**Re: Princeton Cultivation  
3701 Princeton NE  
Traffic Circulation Layout  
Engineer's/Architect's Stamp 2/10/2024 (G16D159)**

Based upon the information provided in your submittal received 5/6/2024, the above referenced plan cannot be approved for Building Permit until the following comments are addressed:

A1 OVERALL SITE PLAN
1" = 20'-0"

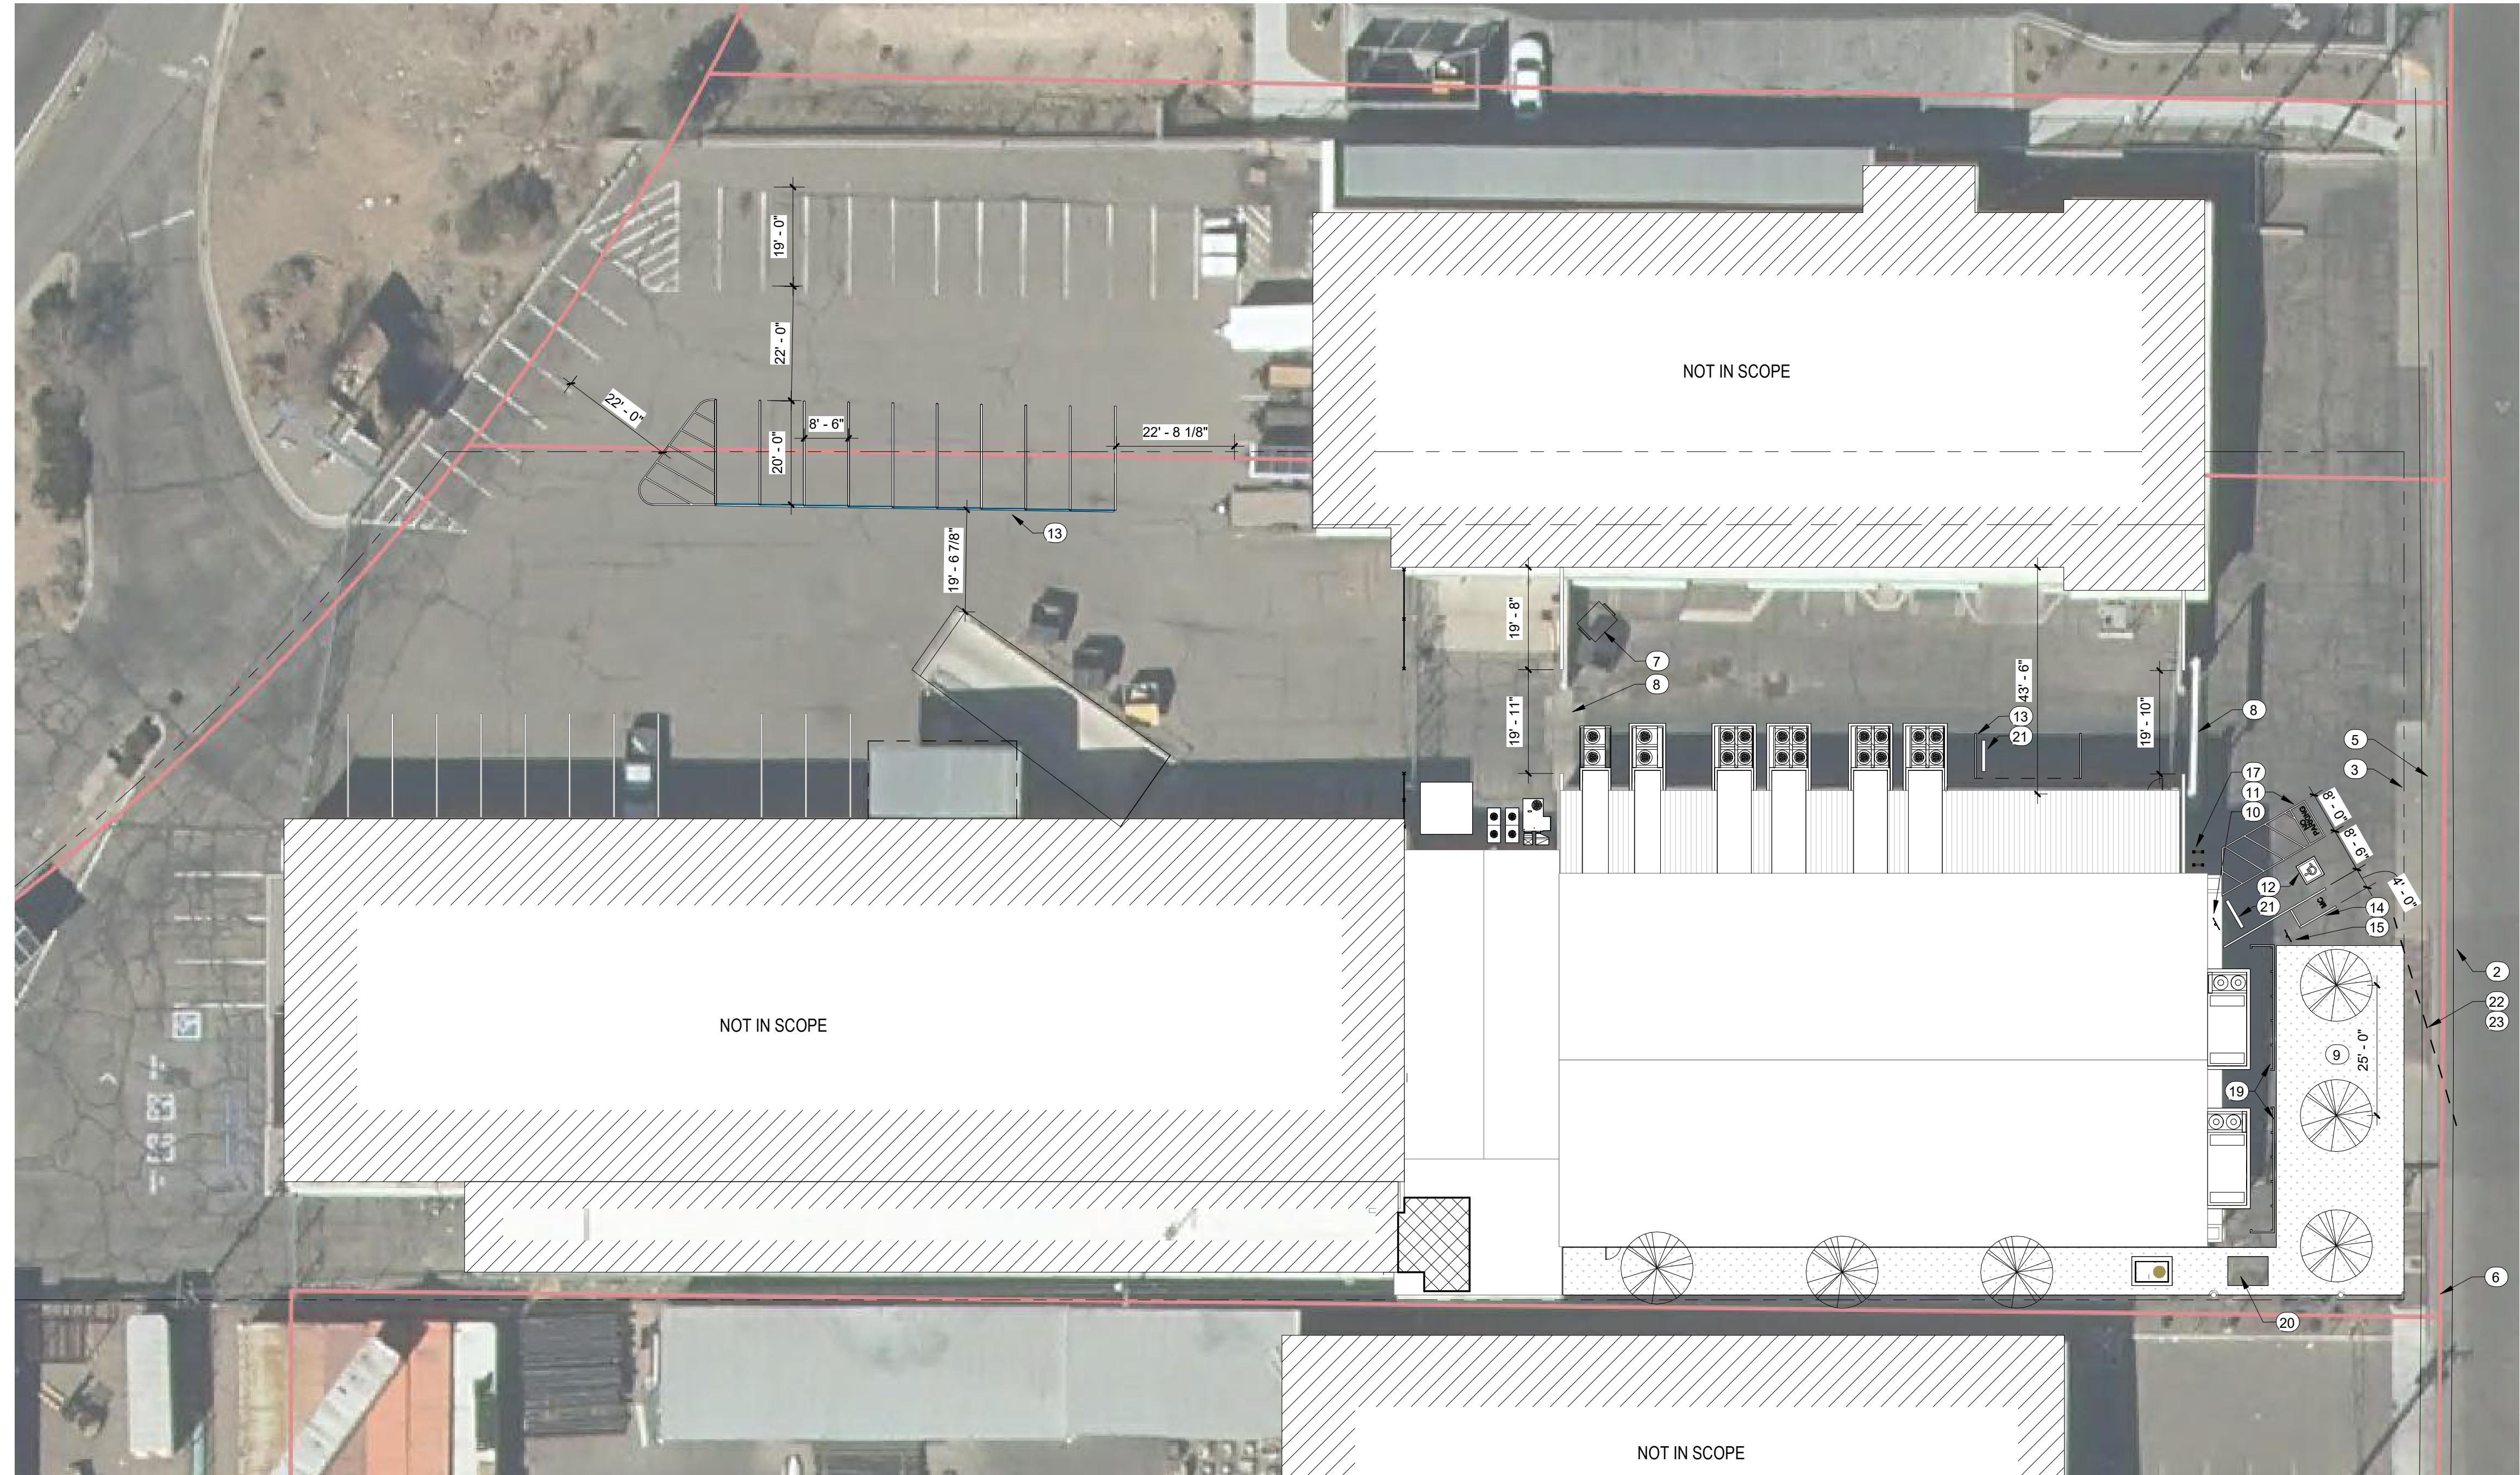
1. Please show the project location correctly on the vicinity map. Please correct the address on sheet LP-01 ( not 3601 it is 3701)
2. Identify the right of way width, medians, curb cuts, and street widths on Princeton.
3. Show the entrance and exit accessways widths
4. Please list the width and length for all existing and proposed parking spaces. Some dimensions are not shown.
5. Parking spaces cannot be bisected by lot lines.

6. A 1-foot clear zone around the bicycle parking stall shall be provided.

7. Bicycle parking spaces shall be at least 6 feet long and 4 feet wide.

8. Per the DPM, a 6 ft. wide ADA accessible pedestrian pathway is required from the public sidewalk to the building entrances. Please clearly show this pathway and provide details.

9. Per DPM, a 6 ft. wide ADA accessible pedestrian pathway is required from the ADA parking stall access aisles to the building entrances. Please clearly show this pathway and provide details.

10. ADA accessible pedestrian pathway should not be placed behind parking space or adjacent to a vehicular way. Vehicle and pedestrian/wheel chair conflicts should be avoided as much as possible.

11. Provide solid waste and fire departments approval
12. All one-way drives shall have "One Way" and "Do Not Enter" signage and pavement markings. Please show detail and location of posted signs and striping.

13. Show the clear sight triangle and add the following note to the plan: "Landscaping and signage will not interfere with clear sight requirements. Therefore, signs, walls, trees, and shrubbery between 3 and 8 feet tall (as measured from the gutter pan) will not be acceptable in the clear sight triangle."

14. Shared Site Access: driveways that straddle property lines, or are entirely on one property but are to be used by another property, shall have an access easement. Please include a copy of your shared access agreement with the adjacent property owner.

15. Add a note stating "All broken or cracked sidewalk must be replaced." A build note must be provided referring to the appropriate City Standard drawing.
